**Builders Recycling Operations Pty Ltd – 191 Miller Rd Chester Hill
State Significant Development MP 06_0052 MOD 3**

The EPA has reviewed the relevant information accompanying the modification application, including report titled, "Modification for the upgrade of the Chester Hill Resource Recovery Facility (MP_0052)" prepared by SG Haddad Advisory and CW Strategic Planning Services, and dated 12 November 2018 (**the Report**).

TITLE				
STORMWATER DRAINAGE				
GROUND FLOOR PLAN				
SHEET 1 OF 4				
SCALE 1:400 @ A3 1:200 @ A1	DRAWN CA	DESIGNED LP	CHECKED LP	APPROVED
DATE Nov 16, 2018	DRAWING No. DA-STW-102			ISSUE D
JOB No. 2016-0932	DEVELOPMENT APPLICATION

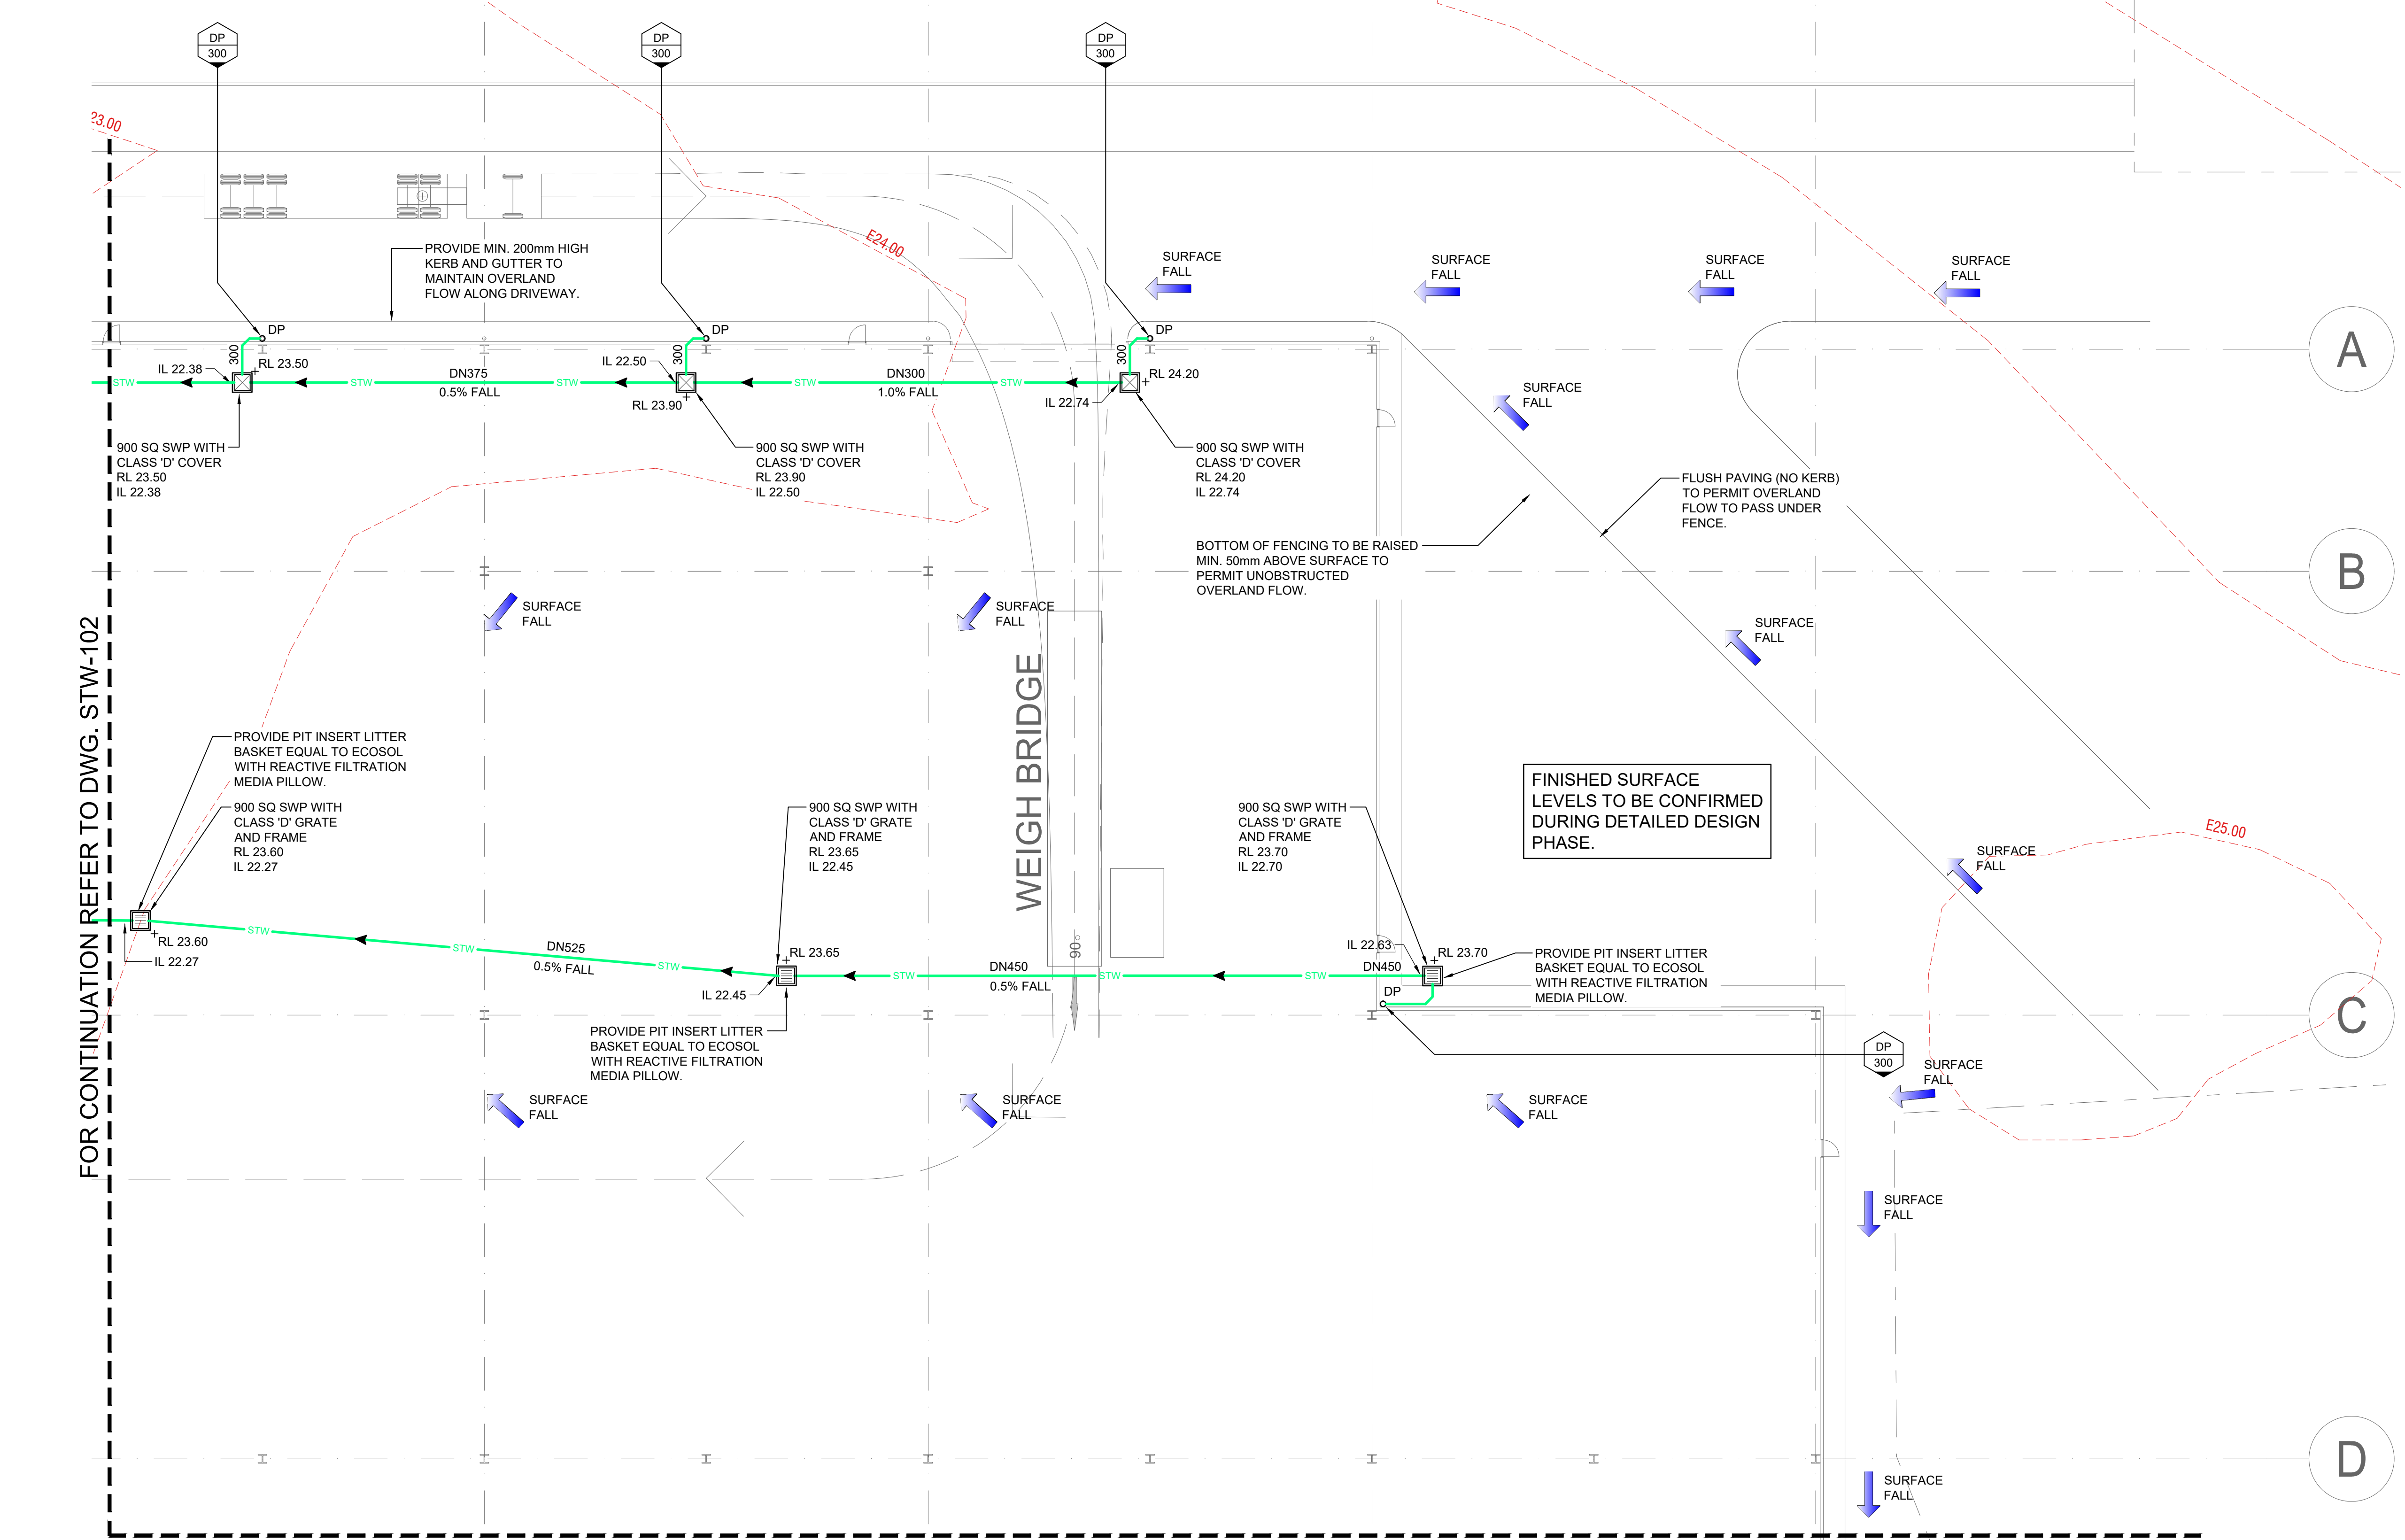
The EPA notes that the “Leachate Collection Tanks” shown on Sheet 1 of 4 are to the north of the “Underground Detention Storage” shown on sheets 3 of 4. The Leachate Collection Tanks are not shown to be connected to anything. The Underground Detention Storage is stated to be for collection of “impervious surface” run off. It is also noted that the “Leachate Collection Tanks” on sheet 1 of 4 are referred to as being for fire services. The EPA requires the Applicant to clarify the purpose of the leachate collection tanks and the underground detention storage and whether they are fully contained or drain to offsite stormwater systems. If it is only roof water and impervious outdoor water that reports to the Underground Detention Storage, then an additional treatment device downstream of the Underground Detention Storage would not be required as this wastewater would be relatively clean and there is a upstream Ecosol Stormpit Class 2 system proposed.

DA-STW-103

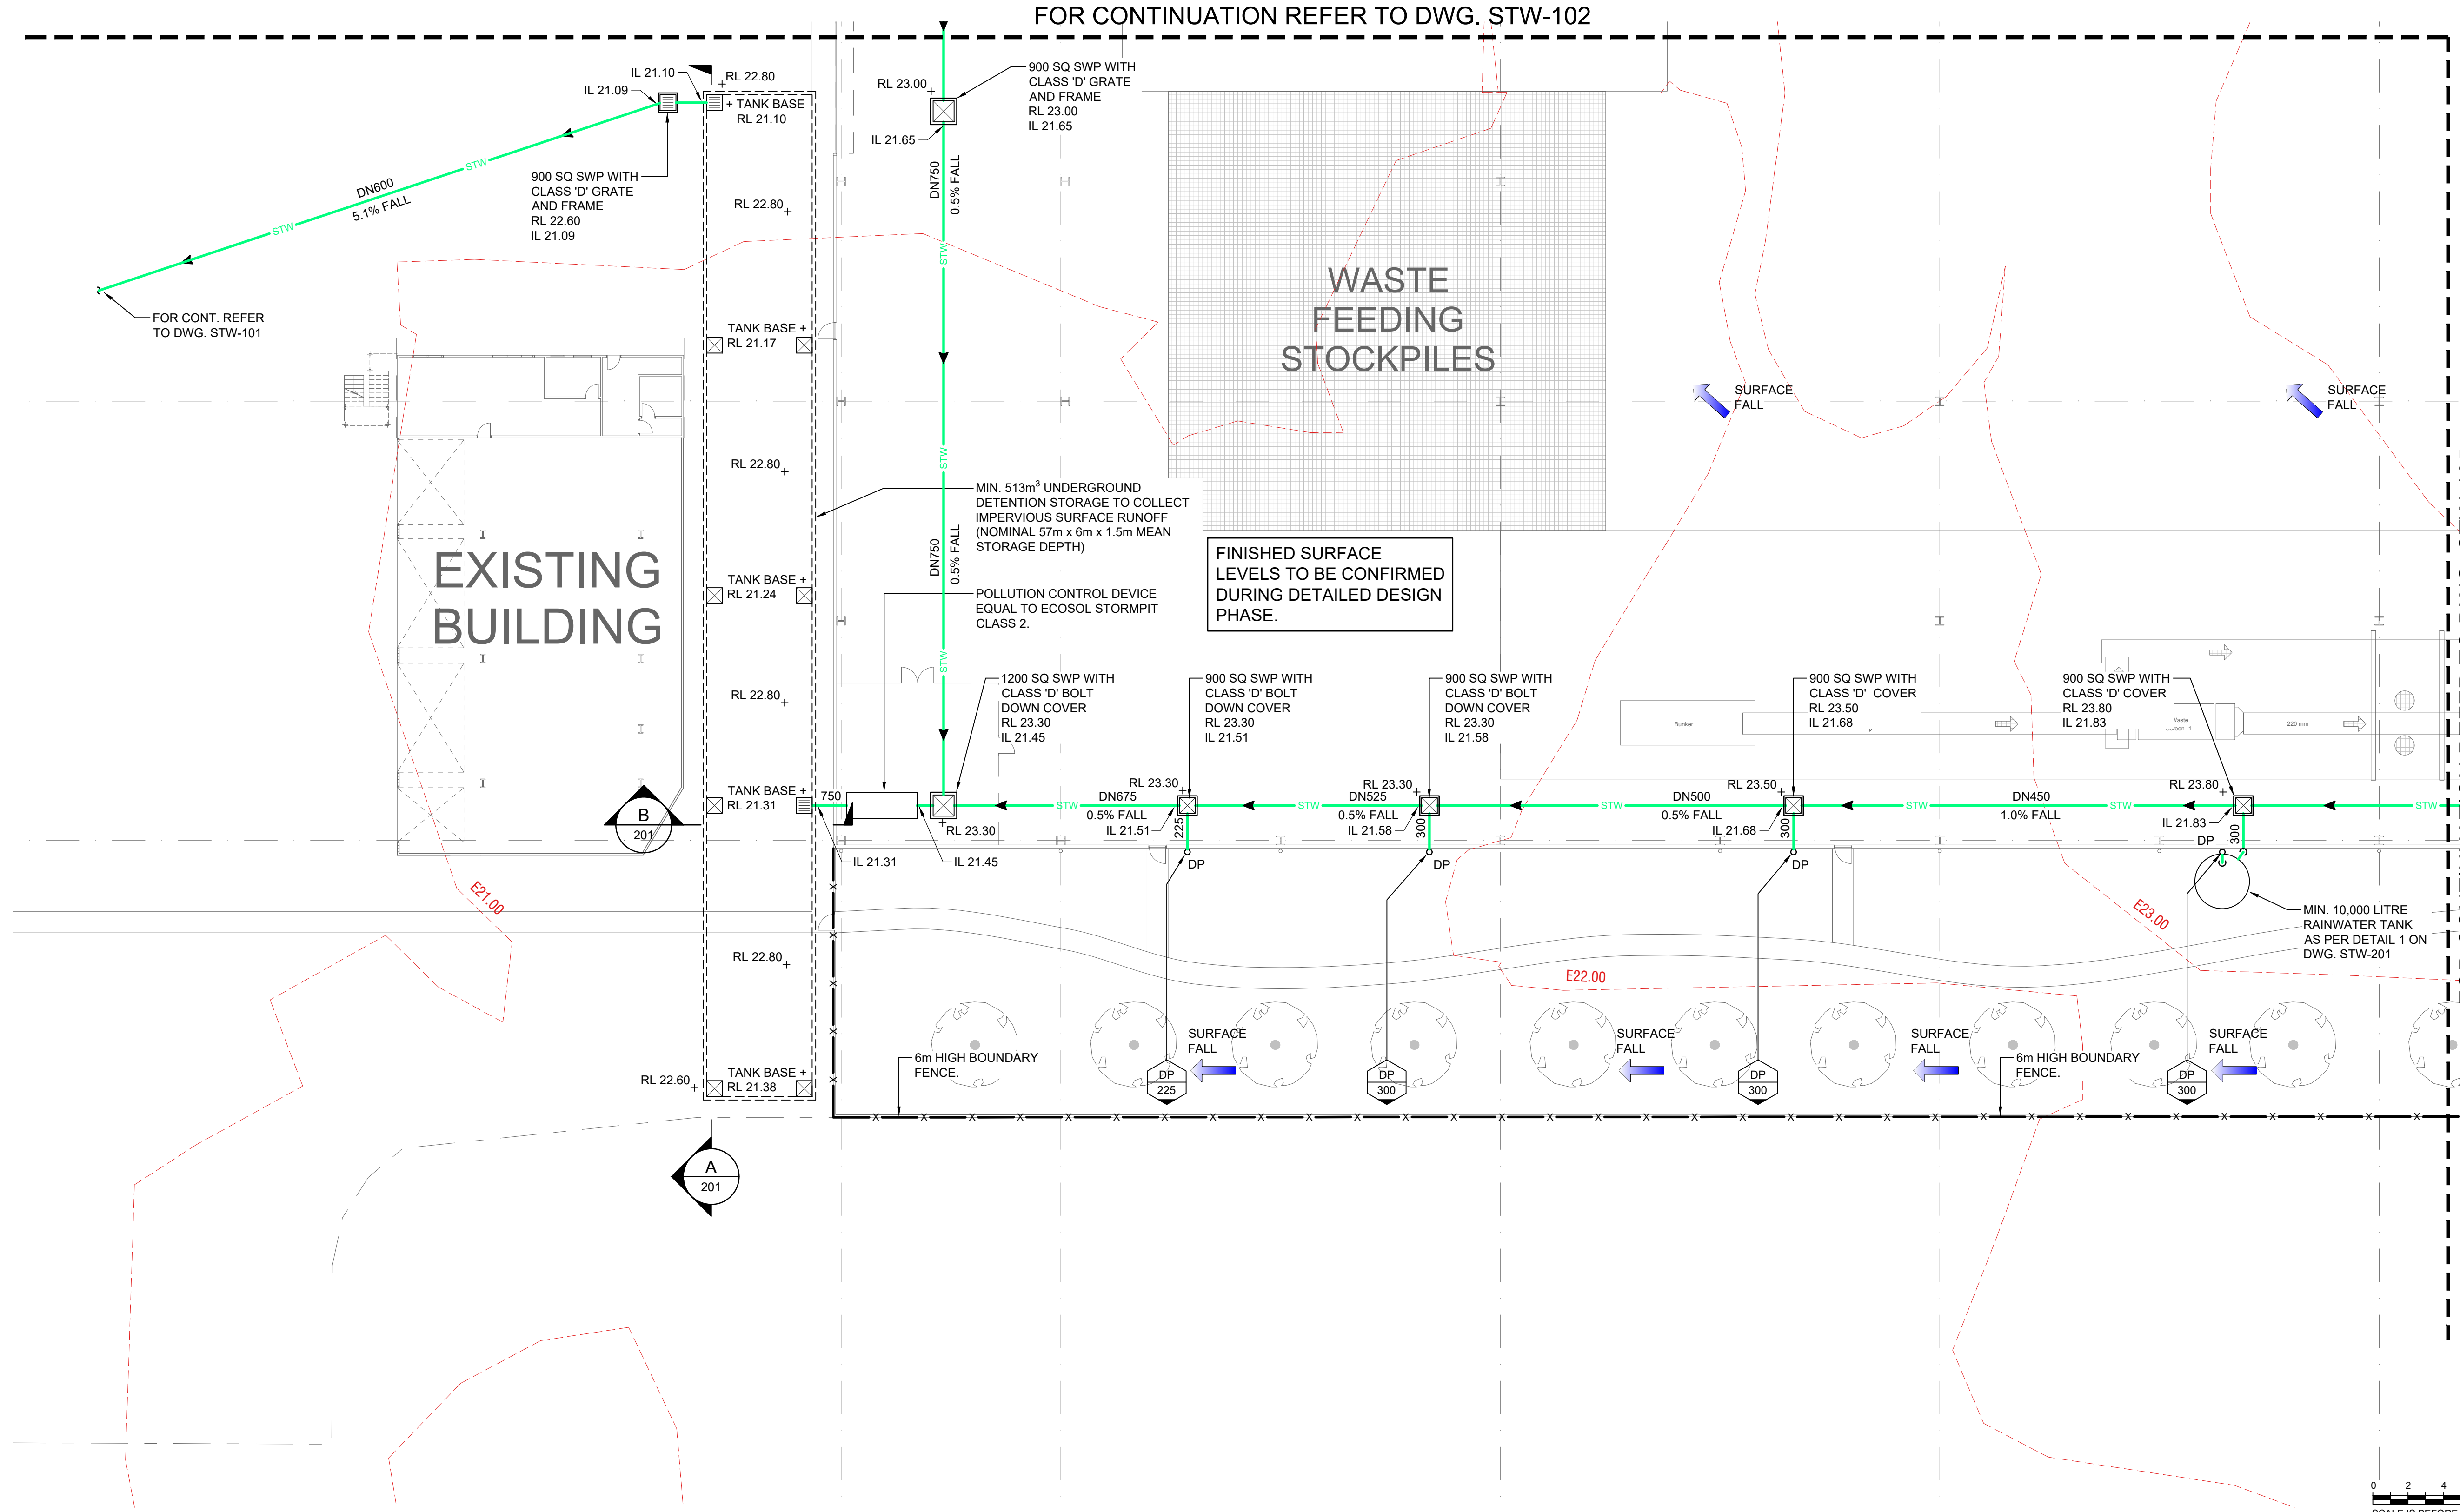
The EPA notes that the plan titled, “Stormwater drainage ground floor plan sheet 3 of 4” shows several SWP pits draining into a Pollution Control Device equal to Ecosol Stormpit Class 2. An Ecosol Stormpit Class 2 system is unlikely to be suitable for treating runoff or leachate from materials and activities within the building. This conclusion is based on monitoring data typical of stormwater runoff from materials being handled. The stormwater drainage floor plans are not clear as to whether there are connections from inside the building to the stormwater system, however it appears this is what the plans are indicating. This is not consistent with the EA which described a system where: *“leachate generated within the sheds will be conveyed to closed collection pits/sumps which are to be isolated.”*

It appears that downpipes from the roof are connected into the internal leachate collection system (Stormwater drainage ground floor plan sheet 3 of 4) which is inconsistent with the EA description of: *“leachate generated within the sheds will be conveyed to closed collection pits/sumps which are to be isolated”*. If leachate/runoff generated within the building is not isolated from other stormwater and the stormwater system, then the discharge assessment in the EA is inadequate as it only considers nutrients, total suspended solids and gross pollutants. The proposed indoor runoff/leachate collection

system must be clarified by the Applicant prior to the EPA being able to adequately assess the proposal.
